From: Julie Trinder <Julie.Trinder@bicester.gov.uk>
Sent: 12 January 2022 12:41
To: Planning
Cc: Phil Evans; Callum McMahon
Subject: Planning Application Department

Reference: 21/01454/F Applicant's Name: Mr Richard Drew Proposal: Proposed Bicester Health and Wellbeing Hub Location: Former Rodney House Private Drive Off, Graven Hill Road

Figure 2: CIHT 'Providing for Journeys on Foot' Preferred Walking Distances on a Map

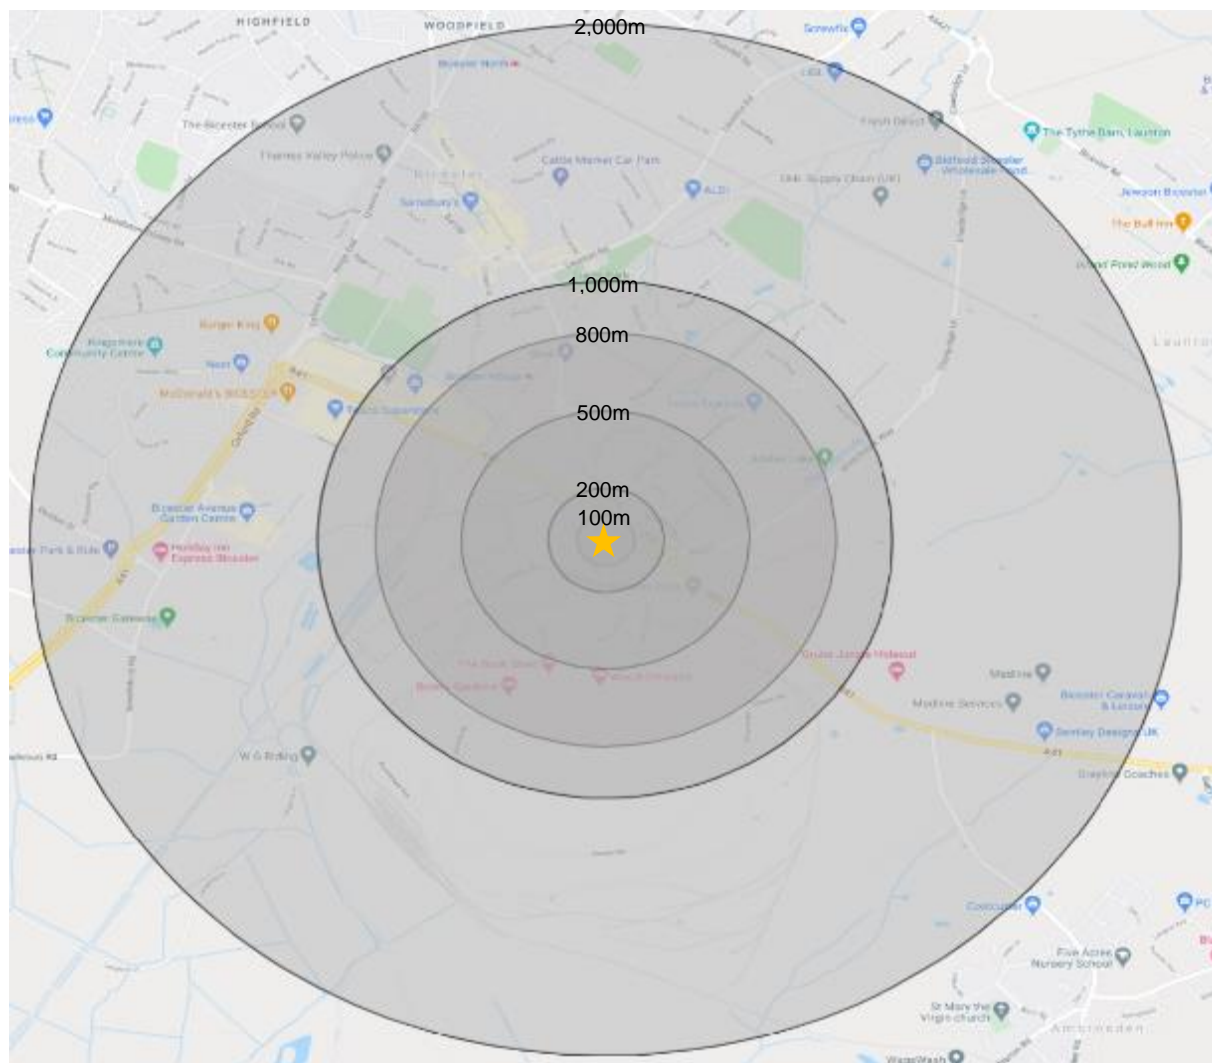
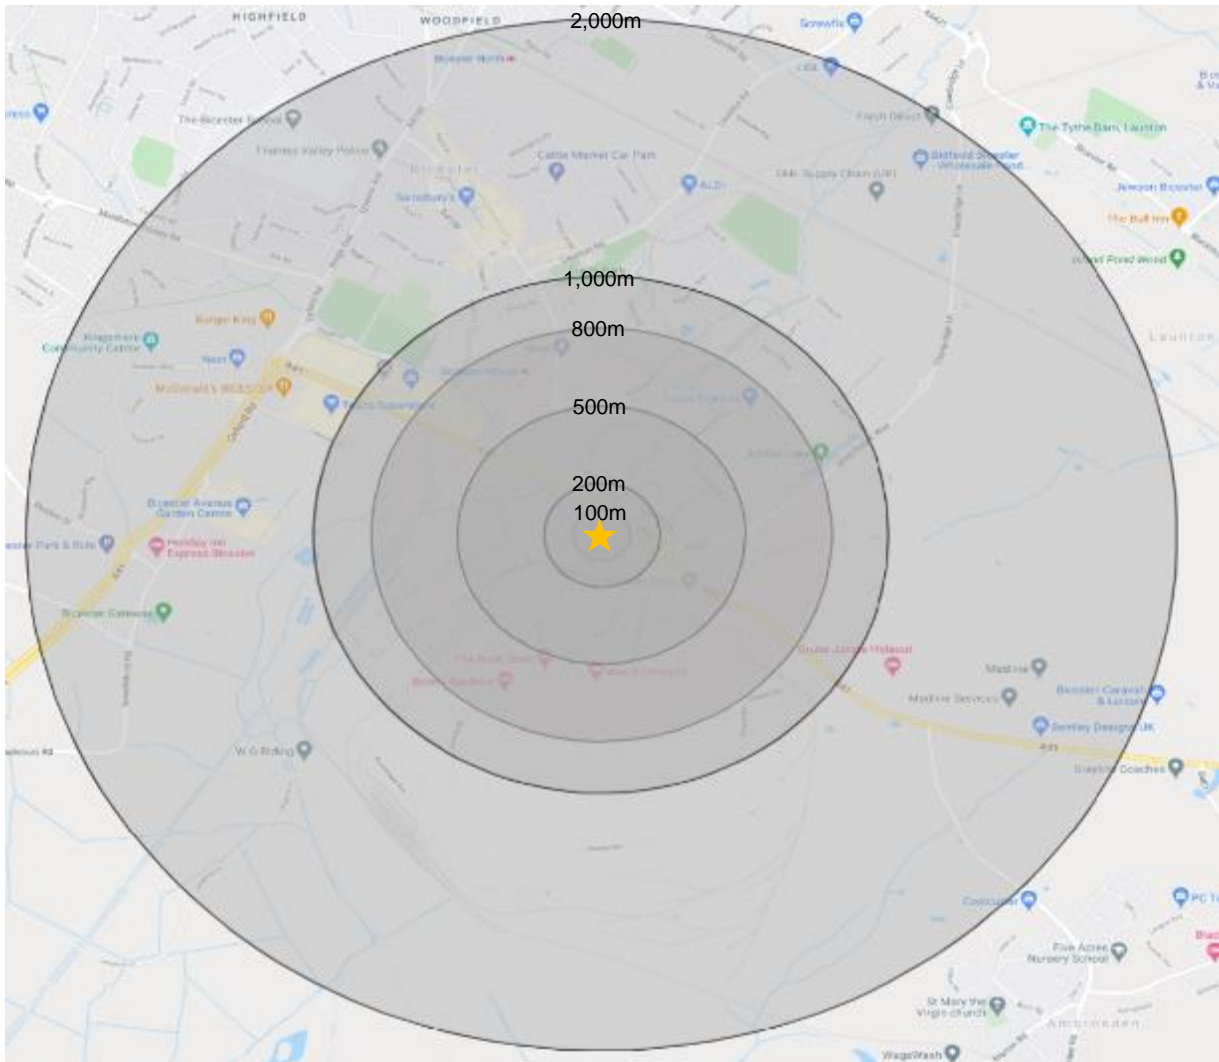
It should be noted that the bus stops in Graven Hill are located circa 170m from the Site and therefore **easily** accessible. I would ask whether stroke victims, long covid sufferers, the elderly or infirm would actually find 170m easily walkable?

The Transport Assessment document quotes selectively from the CIHT 'Planning for Walking' (2015) document ignoring the following paragraph which the Town Council believes should have been taken notice of.

2.4 Many find it difficult to walk. Over the whole population, approximately 15% of people, most of them elderly, have an impairment that affects their mobility. Figure 6 shows how the percentage of people with a mobility difficulty increases with age, reaching over 35% for people aged 70 and over. At all ages, more women report a mobility difficulty than men. A more detailed breakdown by age of the percentage of people with disabilities is available in the Family Resources Survey 2012-2013 (DWP, 2014), but this shows all disabilities, not only those specifically related to mobility. It demonstrates how rapidly disabilities increase as people age past 75 or so. More detailed, though older, studies show that, of people with mobility difficulties, about 70 per cent have difficulties walking, climbing and balancing, (Martin et al, 1988). They show too that about half of people with mobility difficulties are able to get about on their own, provided all pavements and public transport vehicles are appropriately designed (General household Survey 1998). **Martin et al (1988) estimated that 6.2 million adults could not walk 400 yards without a rest, and 3.4 million could not walk 200 yards without stopping or severe discomfort.**

That same document also reminds local authorities of their duties under the **equalities and disability discrimination acts** when considering walking and public transport decisions.

The Transport Assessment also selectively quotes from GUIDELINES FOR PROVIDING FOR JOURNEYS ON FOOT PUBLISHED BY THE INSTITUTION OF HIGHWAYS & TRANSPORTATION 2000

Bicester Town Council notes the following paragraph as there is no mention of other healthcare provision within the above mentioned document, and reasonably expects that the below could be applied to the Health Hub **hospitals generate movements by both able-bodied and mobility-impaired people, and others with a medical condition attending out-patient clinics, who may not be experienced in coping with their mobility difficulties.** The Transport assessment publishes a table from the above document aiming to demonstrate that 200m is a reasonable walking distance However it fails to quote any of the preceding paragraphs in GUIDELINES FOR PROVIDING FOR JOURNEYS ON FOOT PUBLISHED BY THE INSTITUTION OF HIGHWAYS & TRANSPORTATION 2000 These are

3.31. "Acceptable" walking distances will obviously vary between individuals and circumstances. Acceptable walking distances will depend on various factors including:

- **An individual's fitness and physical ability**
- **Encumbrances, eg shopping, pushchair**
- Availability, cost and convenience of alternatives transport modes
- Time savings
- Journey purpose
- Personal motivation
- General deterrents to walking.

3.32. Table 3.2 contains suggested acceptable walking distances, **for pedestrians without a mobility impairment for some common facilities.** These may be used for planning and evaluation purposes. (See also Table 4.2.)

By omitting these crucial points, the original table is mis-represented in the Transport Assessment. The particular needs of a health hub mean that the distances quoted for pedestrians without a mobility issue should NOT be used for planning and evaluation purposes when journeys to and from the Health Hub are concerned.

- a) Ensure that bus services are re-routed to ensure a stop at the Health Hub
- b) Provide for sheltered benches to be made along the route from the bus stop on the spine road to allow elderly and infirm patients to rest along the route.

Figure 9: Existing Bus Stop Locations

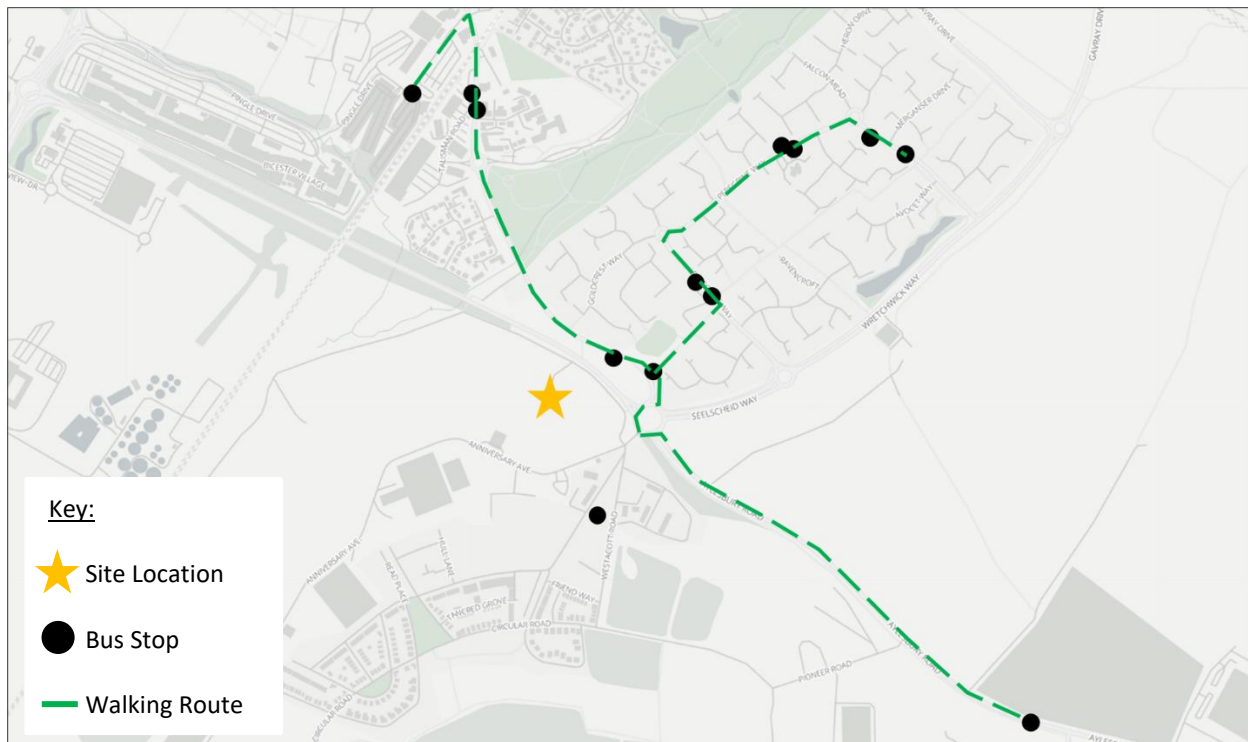
There appears to be a bus stop outside the centre which is great, but we are concerned that the bus will not actually stop there, but will only stop on the spine road. We are concerned that the majority of users will need to take at least two buses to and from the Health Hub with a change on Manorsfield Road. Elderly and infirm residents who live in the East Ward in particular will have long walks both to the bus stop and Bicester North and then from Graven Hill Spine Road to the Health Hub
